Context

Parking

Parking & TDM Strategies

FIGURE 6

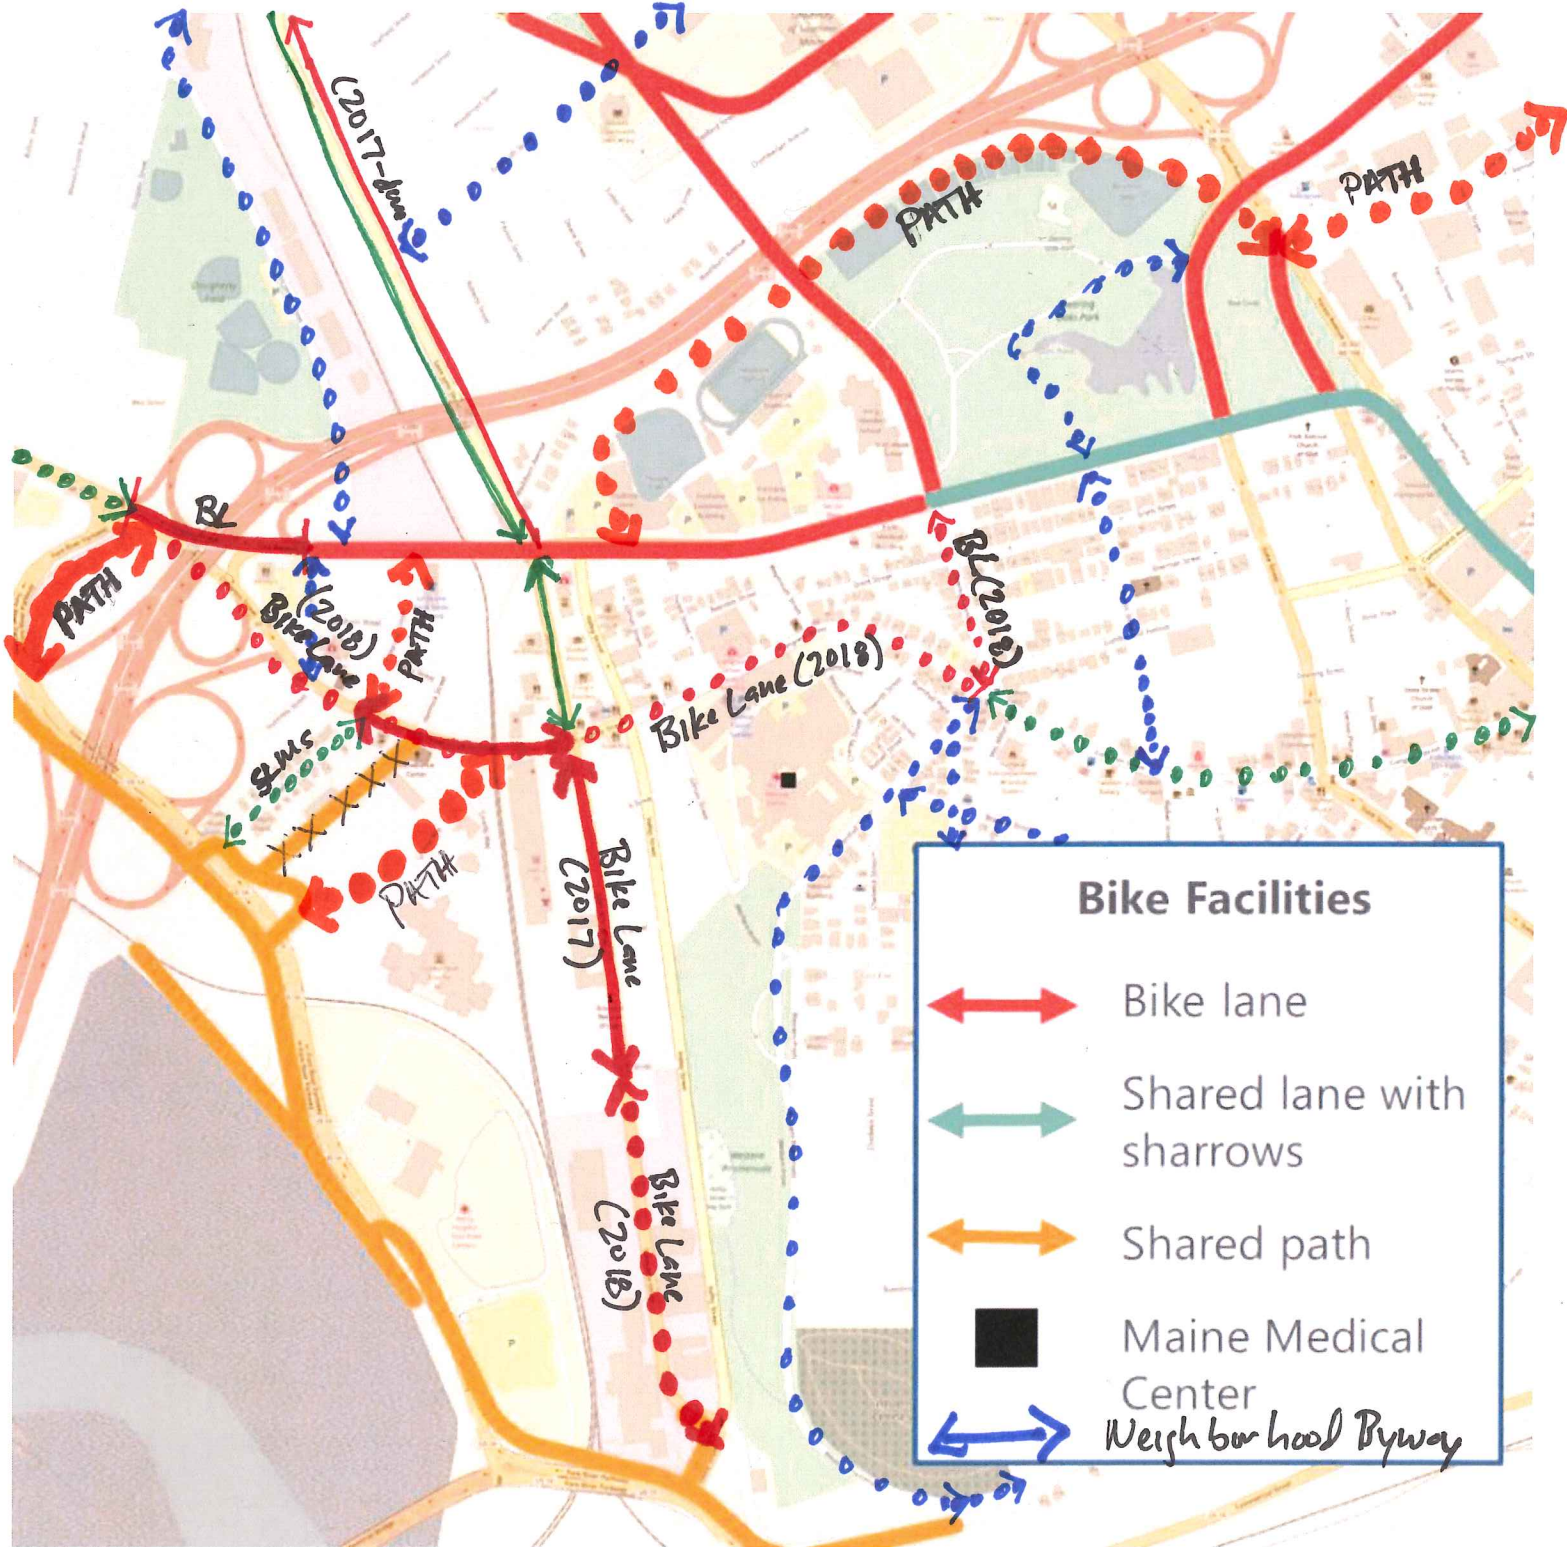
- Figure 6 should include both the existing and proposed bike network (see attached markup).
- The discounts cited in Table 2 are not calculated correctly; the Metro discount is actually 40%, not 60%, etc.
- We would continue to suggest identifying spaces on-campus for preferential carpool/vanpool parking (e.g. some spaces in the visitor garage or surface lots). Preferential spaces in the off-site employee garage are not likely to incentivize change in travel behavior in the way that preferential spaces on campus will.
- The parking cashout procedure seems unnecessarily cumbersome (e.g. submitting a form, etc.). Could this be made easier?
